Planning Inspectorate NSIP ref no TR010038

A47 dualling North Tuddenham to Easton (NTE) TRAFFIC ANALYSIS

Submission from Richard Hawker IP ref No 20028320 Date: 23 November 2021

Figure 4.27: Core scenario DS (DS0) vs Without 'NWL' test DS (DS1) AADT flow diagram

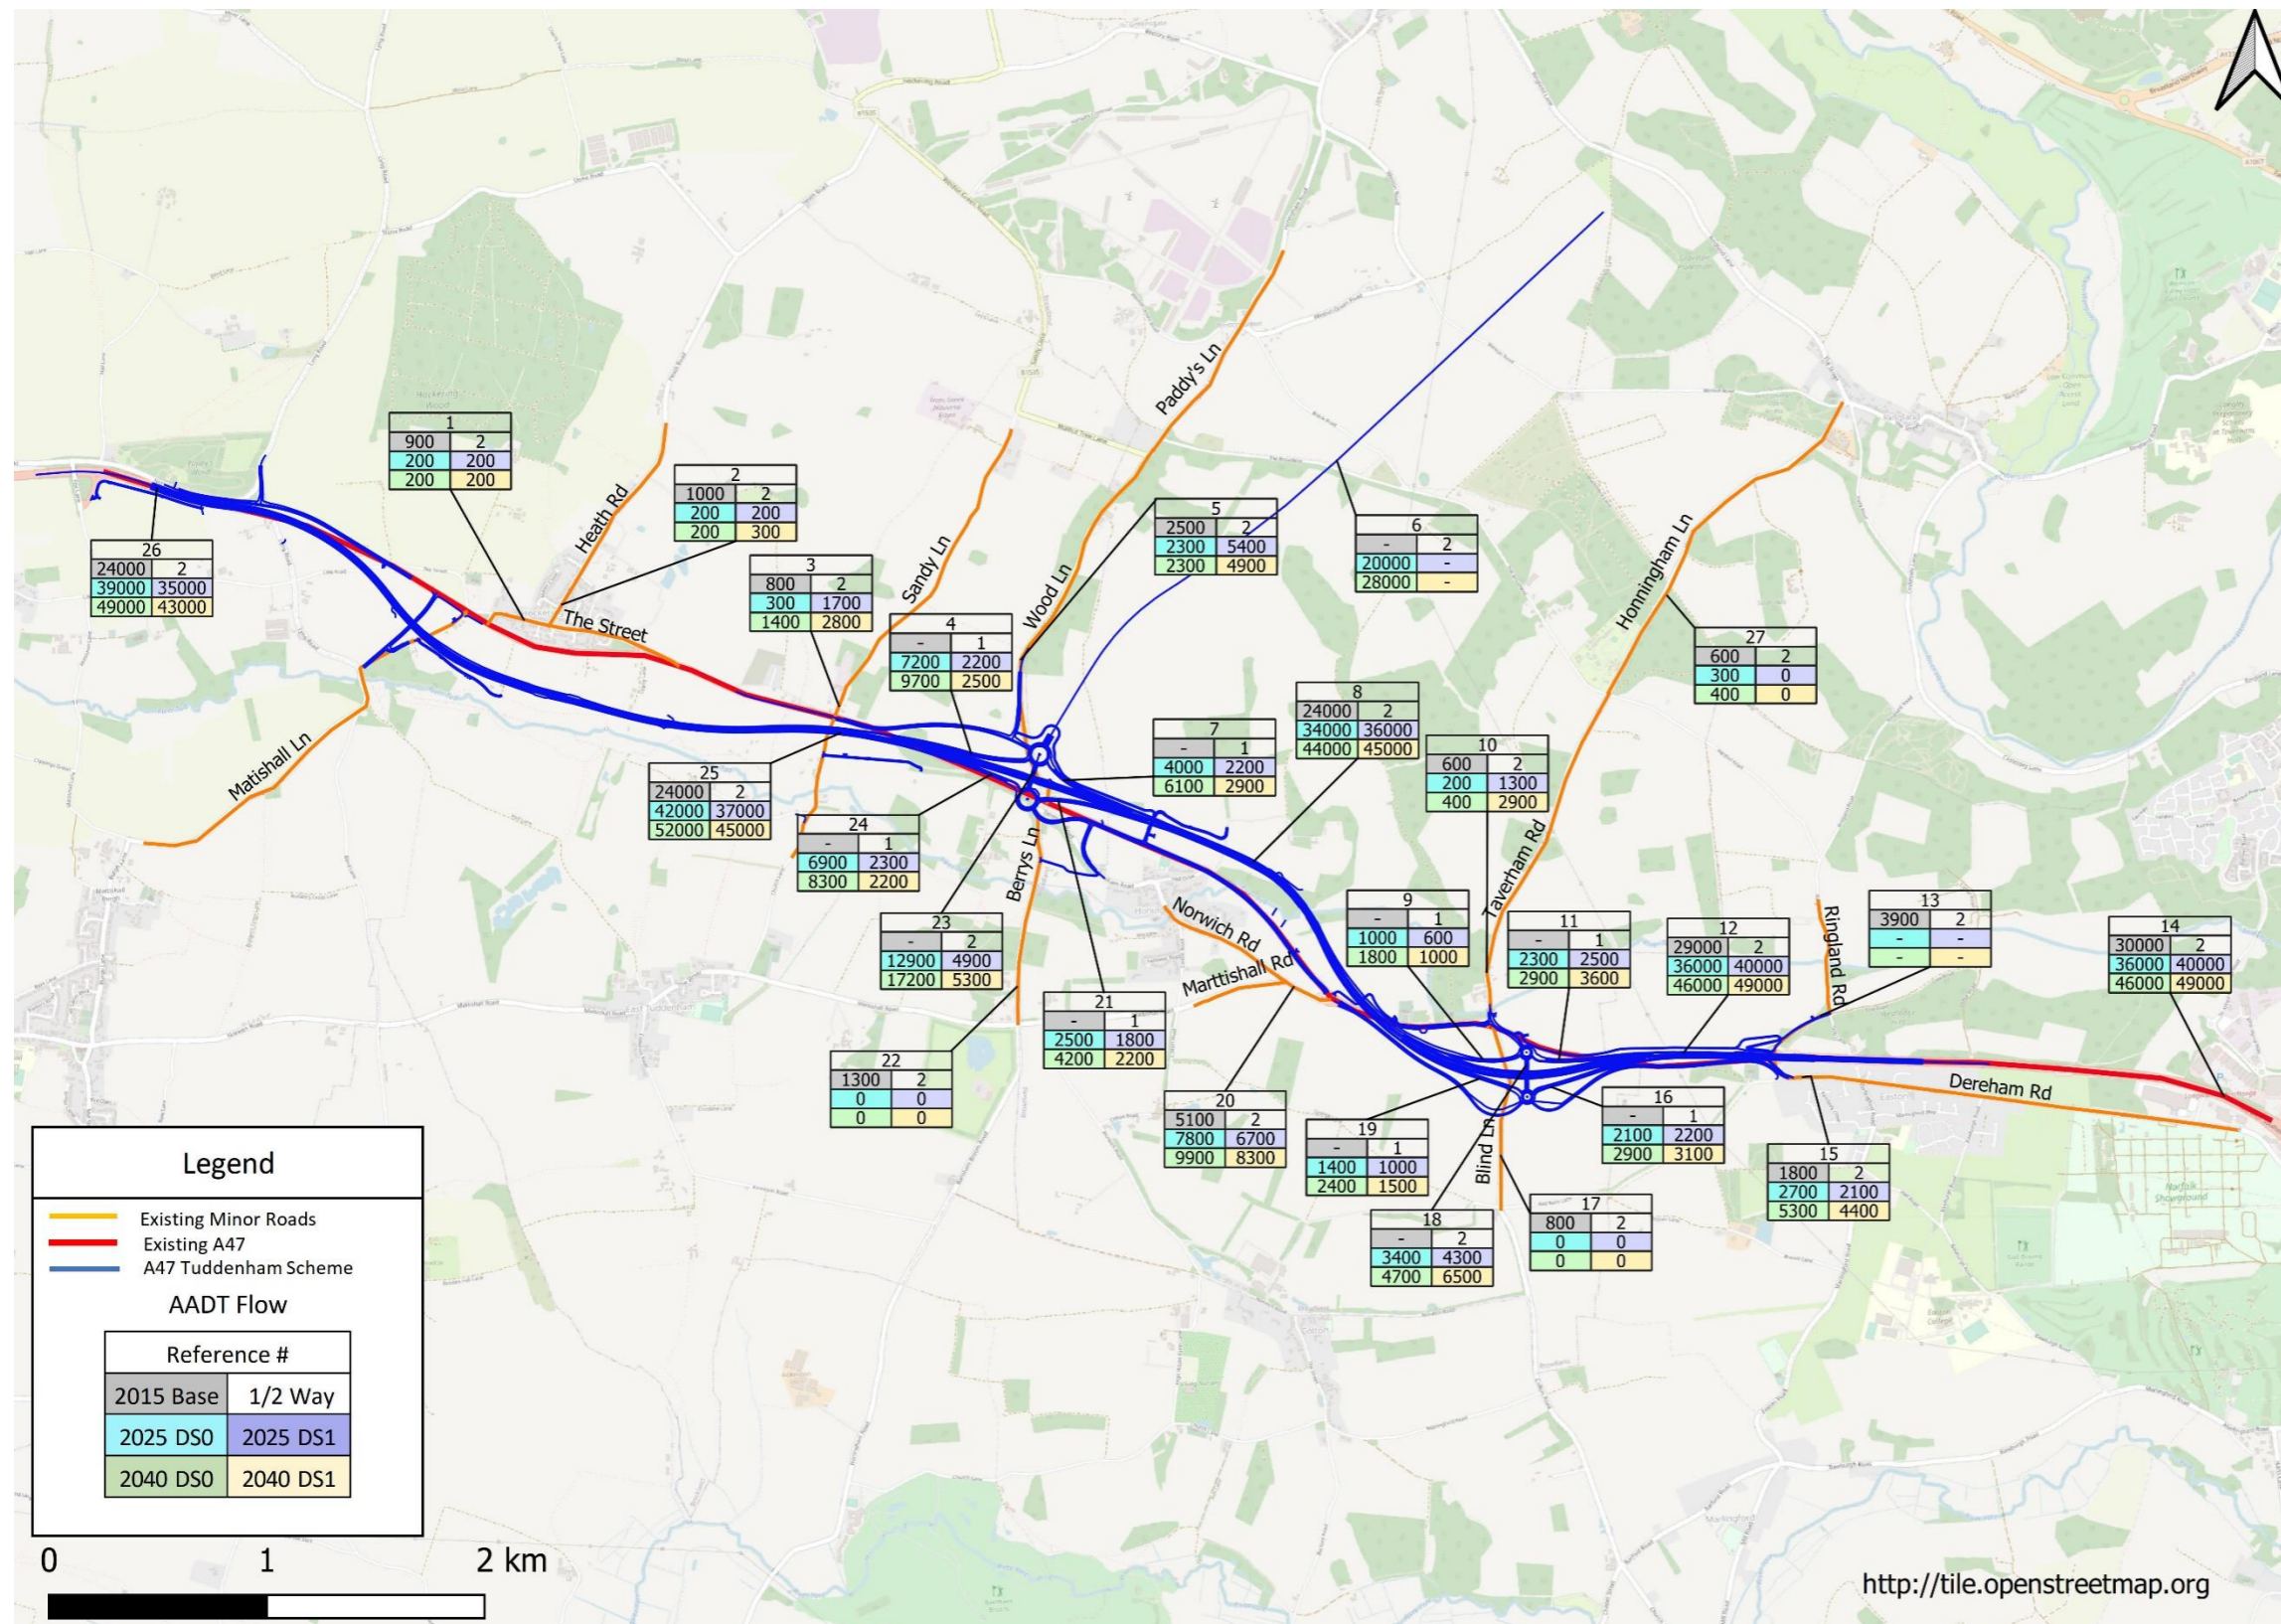
- 1) In the DS0 figures, past Hockering, flow increases from 39k to 42k, at points 25 and 26, yet there are no junctions between these points. **This needs to be investigated.**

- 2) At the next junction, Wood Lane, the mainline drops by 8k. One can assume that a large portion of the 2,300 on Wood Lane will all turn E (if they were going W, from NW of A1067, they would probably have gone through Lyng). Similarly a large portion of the NWL traffic is likely to be heading W, say 75% (15k), and 5k head E, giving a net loss of 10k -2k (from Wood Lane) = 8k. Therefore this looks reasonable, but **it would be good to have other figures to confirm this, especially estimated turning counts, but we are given none.**

- 3) The predicted figures for Wood Lane show only a very slight reduction (200). This **will not achieve the relief from traffic** on that route, (which includes that through Weston L) which is one main reason for building the NWL.

- 4) At the Taverham Rd junction, no access to the FOOD HUB is shown, Blind lane is closed, so the only movements are those on Taverham Road (negligible, at 200) and those from Mattishall Rd and Easton Street. Without turning figures, it is difficult to predict, but if we assume that 10% of the Mattishall Road would turn W (to access Wood La jctn for points N), and 20% of the Easton traffic would turn E (thus avoiding the Longwater jctn), and little traffic between those two arms, then those figures would be reasonably close to those predicted. NOTE that on para 4.3.25 describes and Fig 4.12 shows that an access road to the Food Hub is shown from the ON slip from Easton to A47. **I can see no other reference to this in the proposal.**

- 5) An important question is whether such a large junction at Taverham Road, or a junction at all, is needed for such low figures. If a good link to Berry's Lane were made at Wood Lane junction, all the traffic predicted for Mattishall Road (7800) could join there, although upgrade of Berry's Lane and its bridge would be needed. But it is not at all clear where this 7.8k traffic (2700 extra) is generated; if it is near to Dereham, much traffic would find it beneficial to join at the two junctions in Dereham (except the junction in Dereham can be very congested) and use the dualled A47 for its whole length, rather than the very sub-standard road through Mattishall, so the 7800 figures is an over-estimate. **Origin and destination data needed to clarify.**

- 6) At Hockering, and Sandy Lane, the flow is reduced dramatically (by c1200). But for Wood Lane, the reduction is very slight. One assumes the 1200 (700 +500) vehicles taken from these routes (plus any growth in the ten years) is all handled by the NWL, i.e. that traffic coming from north-west, e.g. Fakenham area, must mostly be assumed to go the considerable extra distance to join the NWL east of Attlebridge (not the B1535, as Wood Lane traffic does not increase.). **This does seem unlikely and needs to be backed up by evidence.**

1) Closing Ringland Lane at Lwr Easton and Honingham Lane displaces 3900 (2015 figure) from crossing the Wensum valley area. (4300 using 2019 5-day figure). By 2025, the changes predicted elsewhere are as follows:

Thus the total vehicles travelling across the area (from the west up to, but excluding Longwater Lane) is predicted to *decrease* over ten years, whereas the overall traffic is predicted to increase. Either the traffic is predicted to use other routes, not covered by the model (or not reported in the submission) or **there is a large error in the model. This needs to be investigated.**

- 1) The addition of the NWL has encouraged 1400 vehicles to divert from using Sandy Lane, but **none** from Hockering. **This must be justified.**
- 2) 5000 vehicles have appeared on the A47 after Sandy lane, though there are no junctions between Wood Lane and Fox Lane. **This does not make sense.**

- 3) 2000 are taken from the A47 E of Wood La/Berry's La, presumably a swap to the more attractive NWL. But if their destination was north of Norwich, what was their previous route? The only other possible way would be via Longwater Lane and Costessey and Drayton, much less attractive than Wood Lane and Lenwade. This seems very unlikely and **needs to be checked.**

- 4) An extra 1100 have appeared on Mattishall Road. It is difficult to see where their previous route would have been, for the introduction of the NWL to be an attraction to use Mattishall Road. Even were they to have used the Taverham Road to cross the valley, they still would have to use Mattishall Road.

- 5) 4000 fewer travel on the A47 E of Taverham Rd than with NO NWL, but 2000 more than E of Berry's Lane. Few are shown joining at Taverham Road, so they must come from Mattishall Rd (7800), less those joining from Easton (which are 2700 in total and surely not all going W) giving around 5000 extra. **This needs to be explained.**
